A57 Link Roads

TR010034

**Draft Statement of Common Ground with
Derbyshire County Council**

November 2021

**6.4 Environmental Statement
Figure 6.1 Designated Heritage Assets**

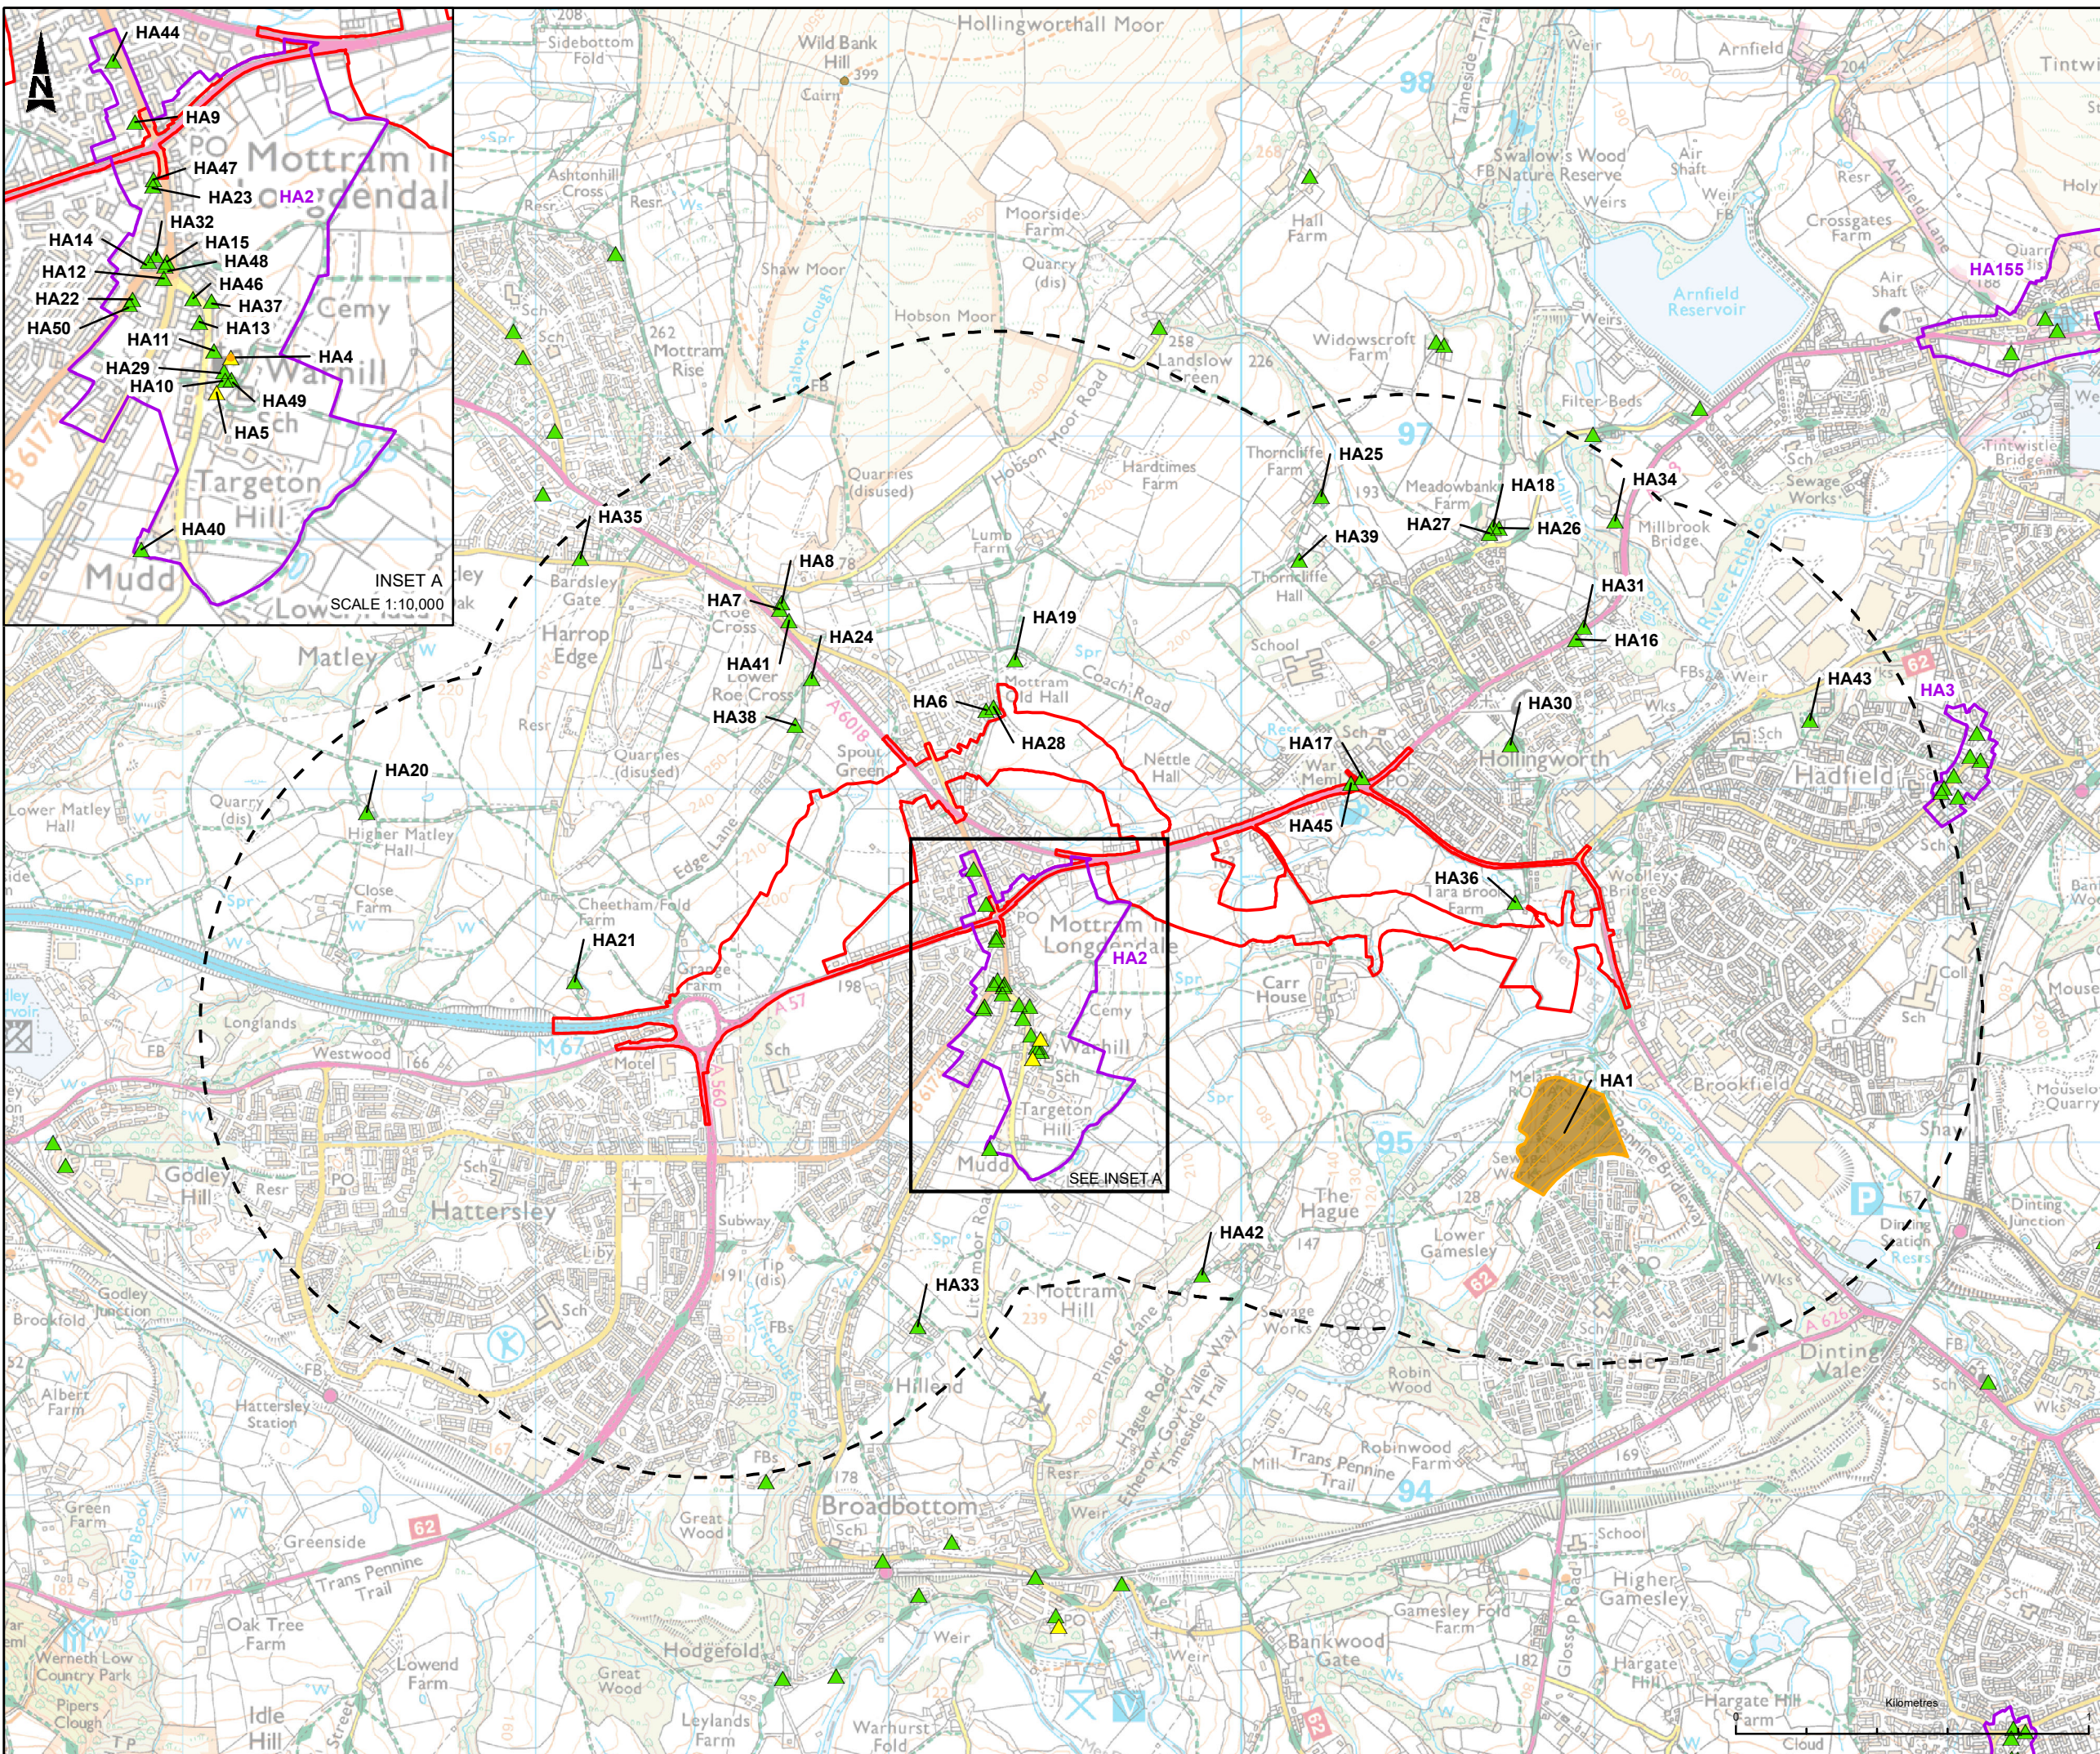
| SoCG Ref. Number | Relevant examination document | Relevant Issue | DCC Comment | National Highways response | Status |
|------------------|--|---|--|---|--------|
| 3.4 | Environmental Statement (ES) Chapter 6 – Cultural Heritage [APP-062] | Archaeology & Cultural Heritage Methodology Melandra Castle | It indicates that the assessment of setting impacts to Melandra Castle should comprise a setting study following the five-step principle established in Historic England guidance and include appropriate viewpoint photography/ photomontages to show the potential impacts of the development. | The Applicant undertook the assessment in relation to this guidance. | Agreed |
| 3.5 | Environmental Statement (ES) Chapter 6 – Cultural Heritage [APP-062] | Archaeology & Cultural Heritage Methodology Melandra Castle | The Consultees stated it that it had requested additional viewpoints of Melandra Castle but could not see them within the consultation materials. | The Applicant stated that it currently had three representative Viewpoints in the vicinity of Woolley Bridge and Melandra Castle: a) View from the Woolley Bridge (A57) adjacent residential properties: b) View from Trans Pennine Trail c) View from PRow HP12/72/3 adjacent Melandra Castle (SAM) | Agreed |
